SUBJECT/RE: Kittitas Permit # LPF 22-00007 Forest Ridge Phase V
Contour Project #21-088

Below are our responses to your November 15, 2022 RFI for the Forest Ridge Phase V Final plat. As stated in emails, this response is in coordination with Forest Ridge Phase IV Final plat being accomplished by Encompass Engineering. See the responses below:

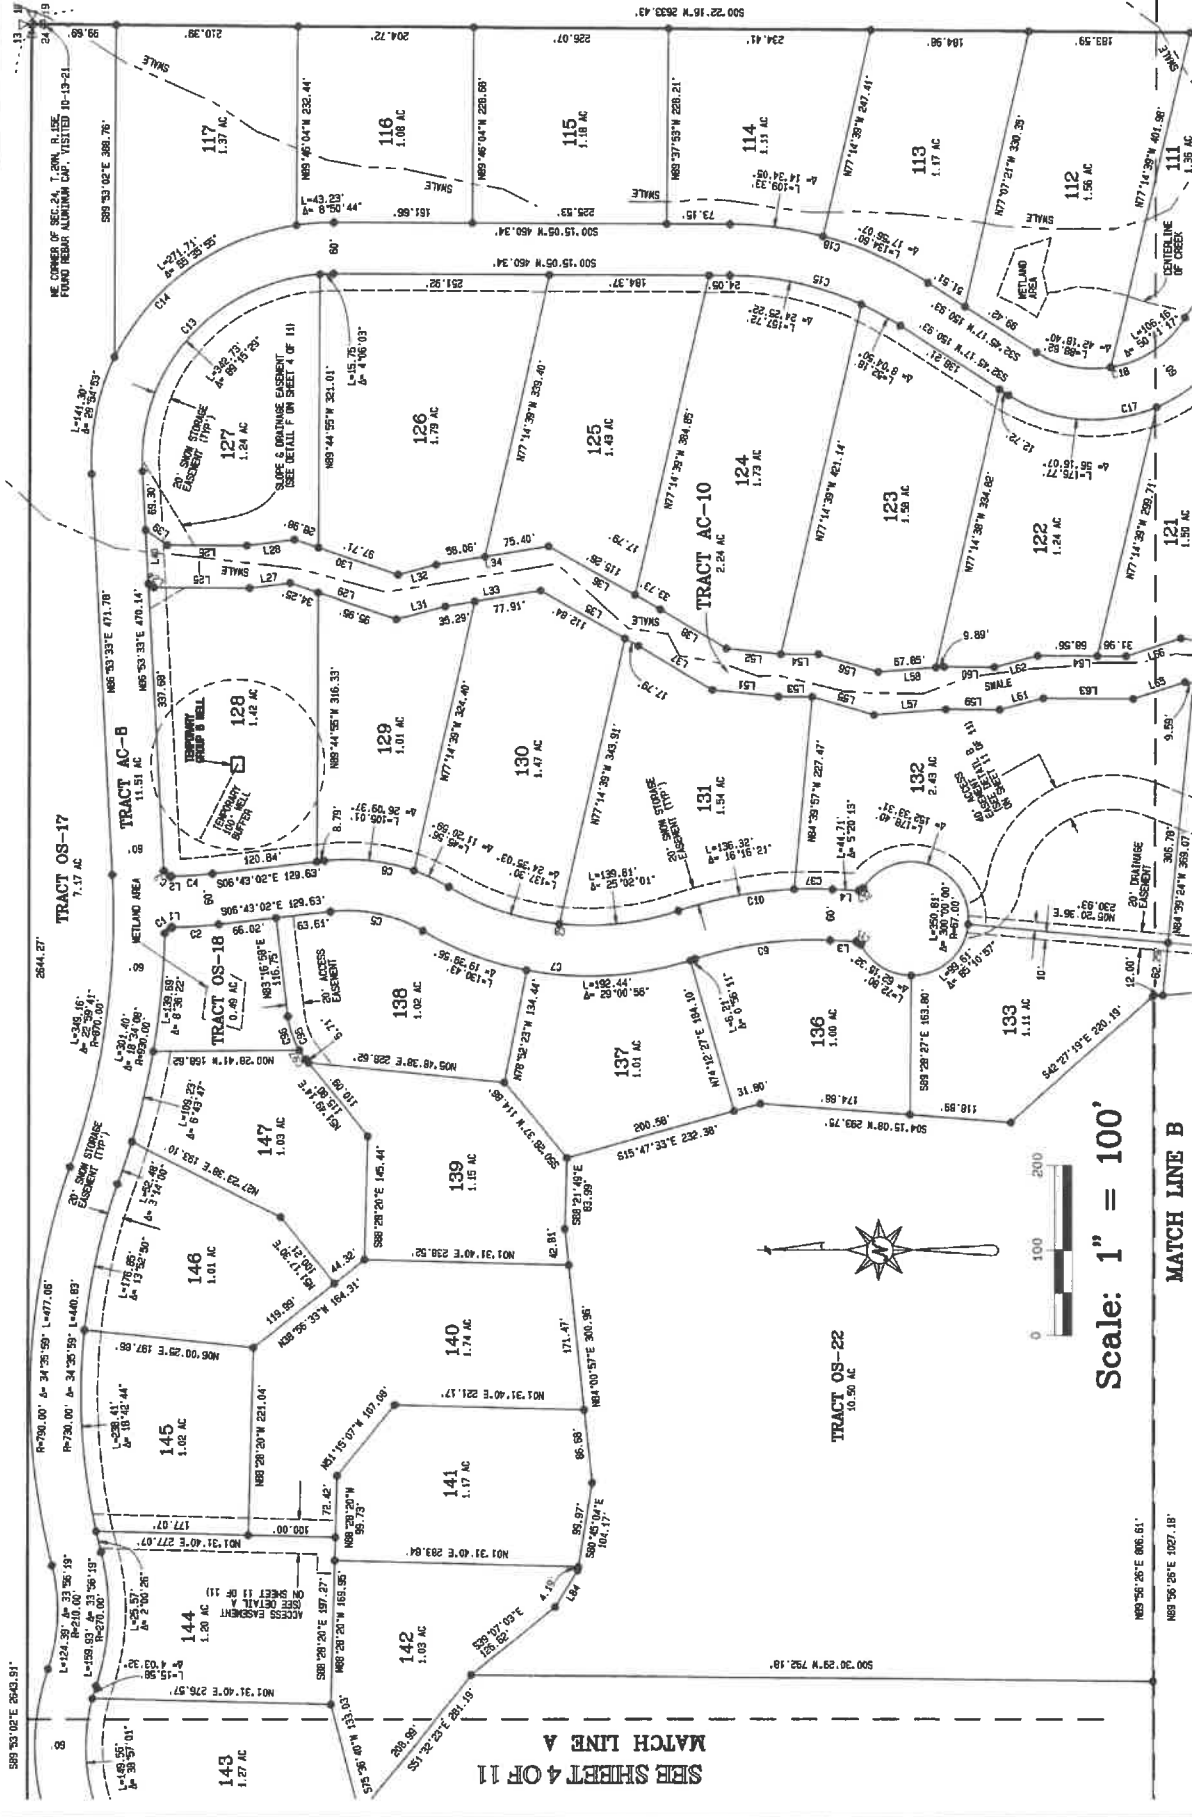
Sheet 2:

3. Include labels for adjacent plats with recording numbers (EX: Plat Bk:10, Pg.4)
Added
4. Under existing legal description, change “Recorded of said County” to “Records of said County” (3 occurrences)
Changed (3 occurrences)
5. In the Legend Change “Forest Ridge-Phase III” to “Record Info per Forest Ridge-Phase III”
Changed
6. The South line of SW 1/4 of Section shows a record distance that does not match the reference (.84 vs .80)
Changed to match the reference
7. The two calculated section corners that are also property corners will need to be set and shown on the face of the plat.
Corners will be set and are shown on the face of the plat

SHEET 4 OF 11

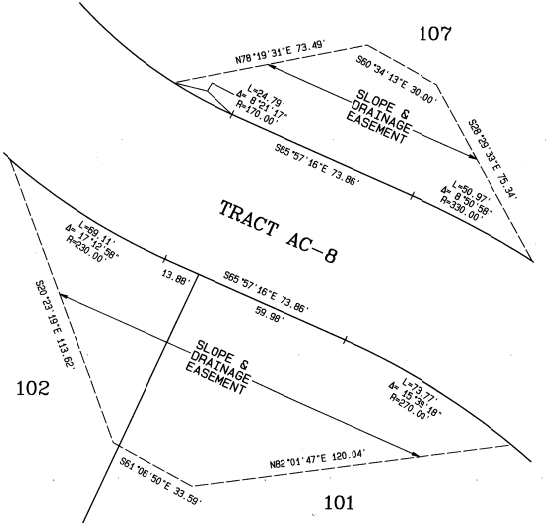
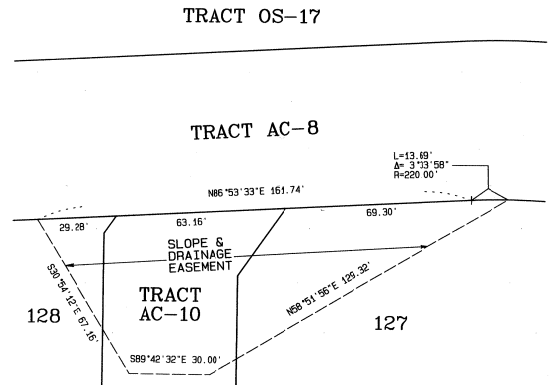
Sheet 4:

8. Lot Closure report calls out a distance of 0.36 feet near the N1/4 corner of section, which is not shown on the plat. This corner will also need to be set.
Added a detail and corner will be set.
9. Show all easements as “Existing”, “Herein Dedicated”, or “Created by Separate Document” (or similar language).
Added language to easements.
10. The area containing Tags L1, L2, C3 and C1 would benefit from a detail window (not required).
No changes made.
11. Show the total Width of Tract AC-10.
Width added and tract renamed to OS-26
12. Identify the dashed lines on either side of Stream E and F.
Buffer lines identified

INDEX DATA:
SEC 24 T20N, R15E, WM
SURVEY FOR: SKYLINE RIDGE LLC
405 NW GILMAN BLVD, STE 102
ISSAQUAH, WA. 98027
KITTITAS COUNTY, WASHINGTON
SHEET 6 OF 11

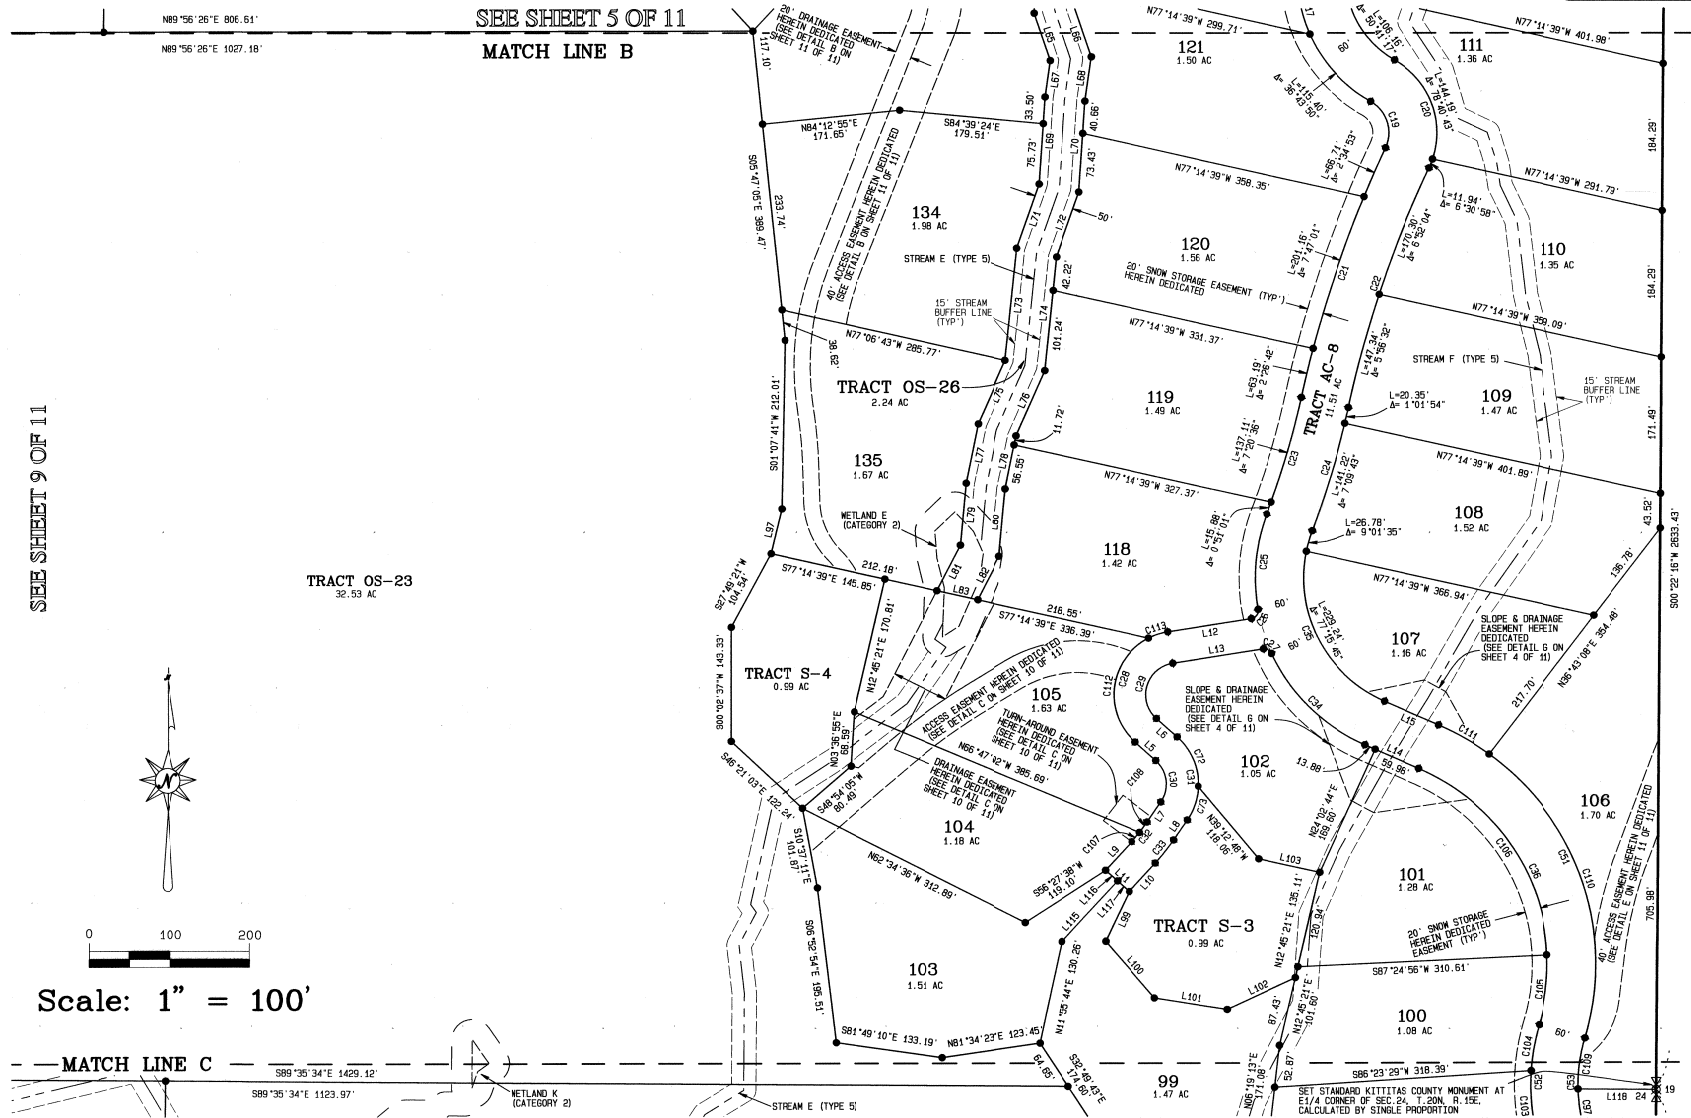
Sheet 6:

13. The Calculated East 1/4 corner of Section will need to be set.
Modified label.

SHEET 7 OF 11

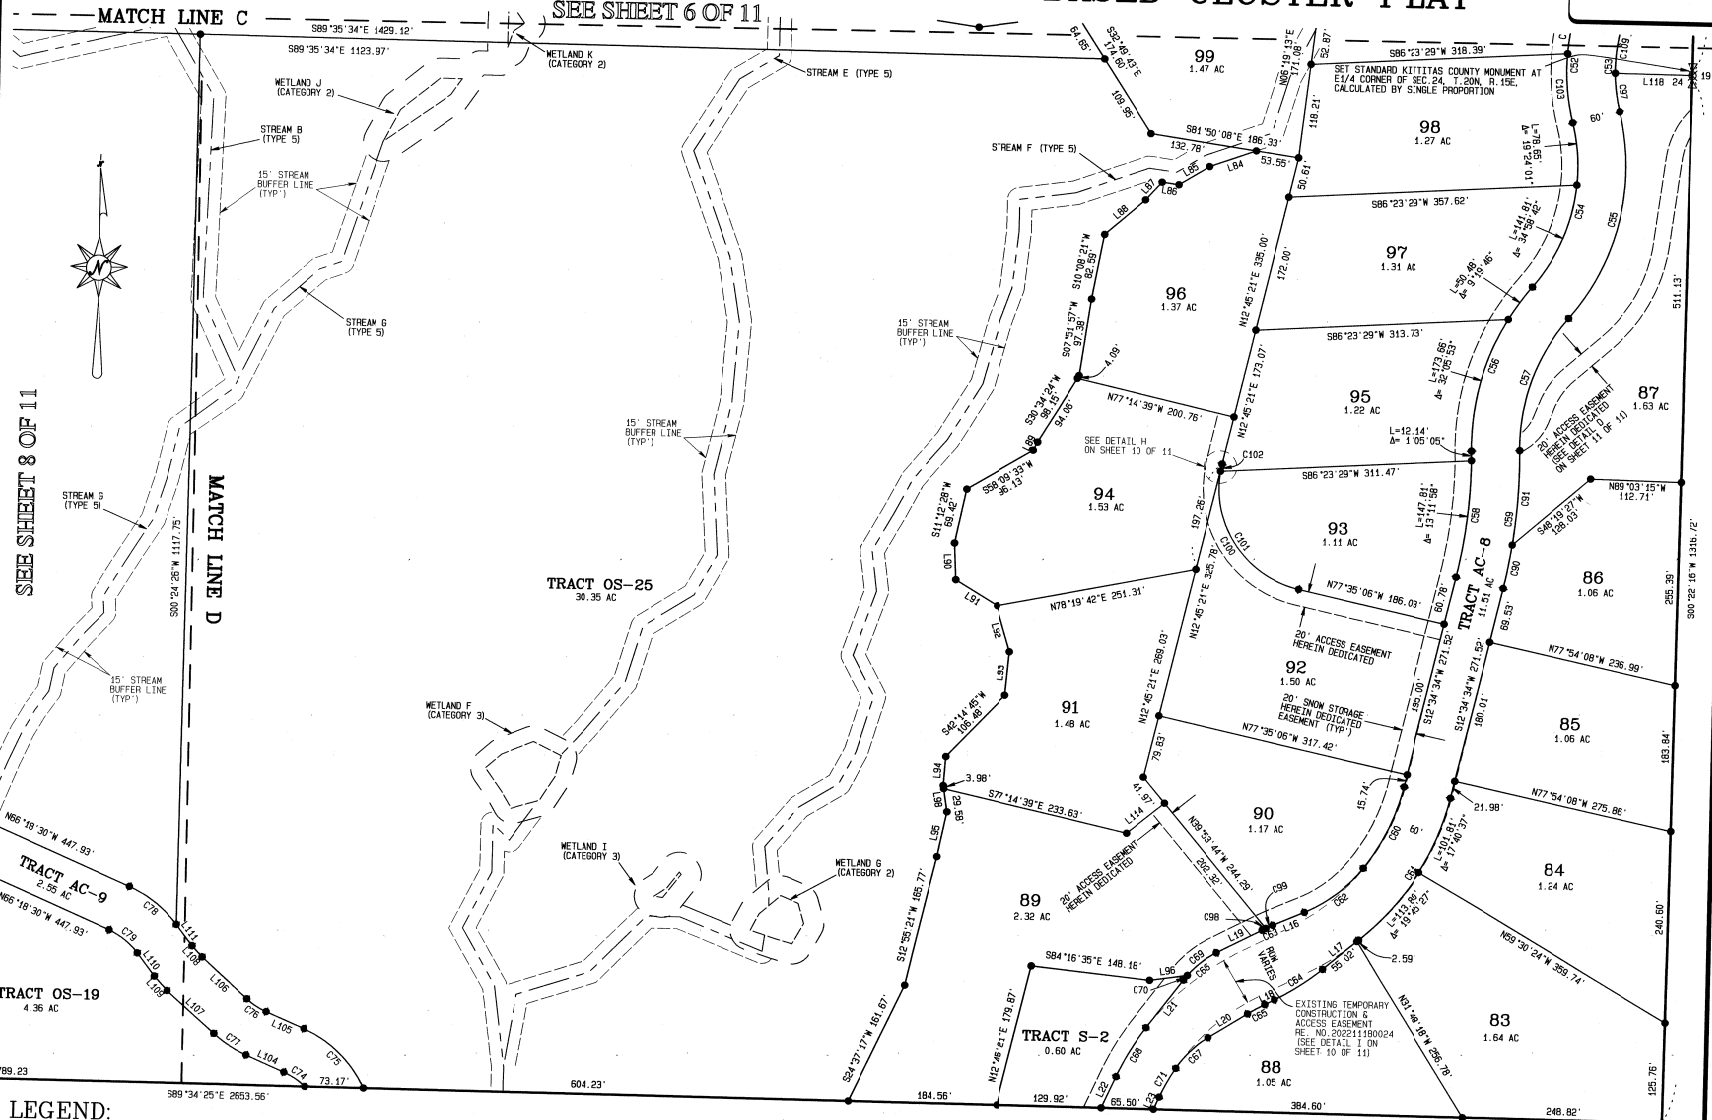
14. The area Curve Tag C102 would benefit from a detail window (not required). If a detail window is not used, “tick marks” or “crows feet” identifying the ends of the 197.26 long line would clarify things.

15. Spelling typo near Eastmost corner of Tract S-2 “ROW VARIES”

Added crows feet and included a detail drawing for clarity

Corrected typographical error.
